Rezoning Petition Review – Charlotte Tree Ordinance

Subject: Urban Forestry Rezoning Petition Review Summary
To: Charlotte Planning, Design & Development
From: Tim Porter, Chief Urban Forester
Timothy.Porter@Charlottenc.gov
 704-622-4829
Rezoning Petition: 2021-100

Date	Description/Status
9/23/2021	UF 2 nd review, Tim Porter
8/26/2021	UF 1 st review, Tim Porter

CONCEPT
SITE PLAN

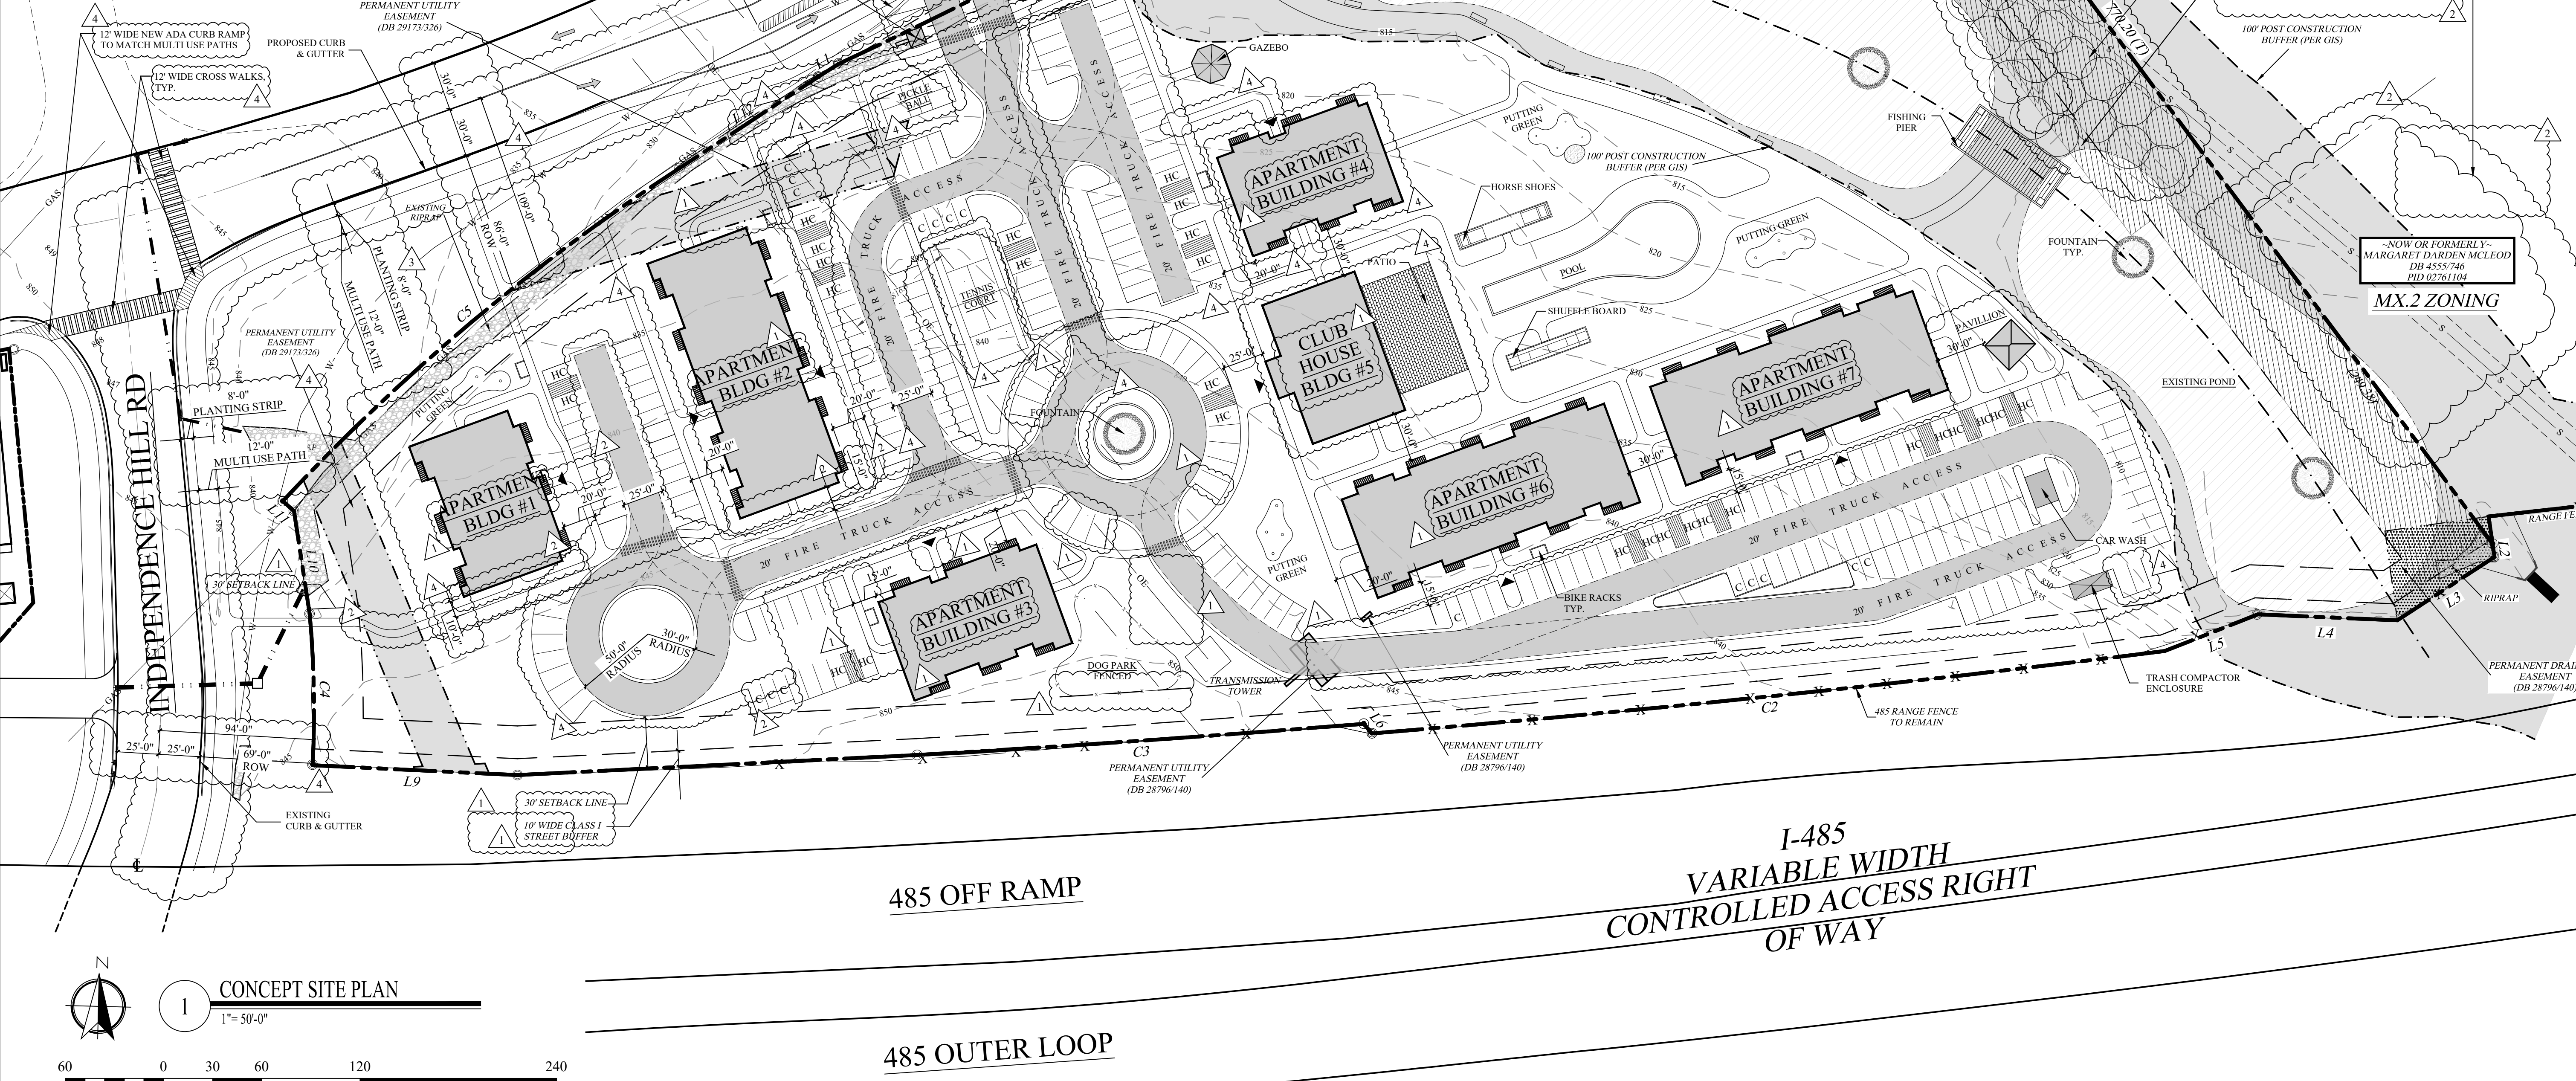
- Conditional rezoning petition submittals shall provide notation referencing how tree save requirements will be met by the site and depict potential tree save areas.

- Conditional rezoning petition submittals shall depict potential tree save areas if on-site tree save is required; or provide notation referencing how tree save requirements may be met if site qualifies for options (payment-in-lieu, green roof, off-site tree save).
- ~~— A tree survey shall be submitted identifying all trees of eight inch (8) dbh or greater and all planted trees of (2) two-inch caliper or greater and six feet in height that grow partially or wholly within public street right-of-way.~~
- ~~— Site is located in NE Wedge. Remove not referencing corridor.~~
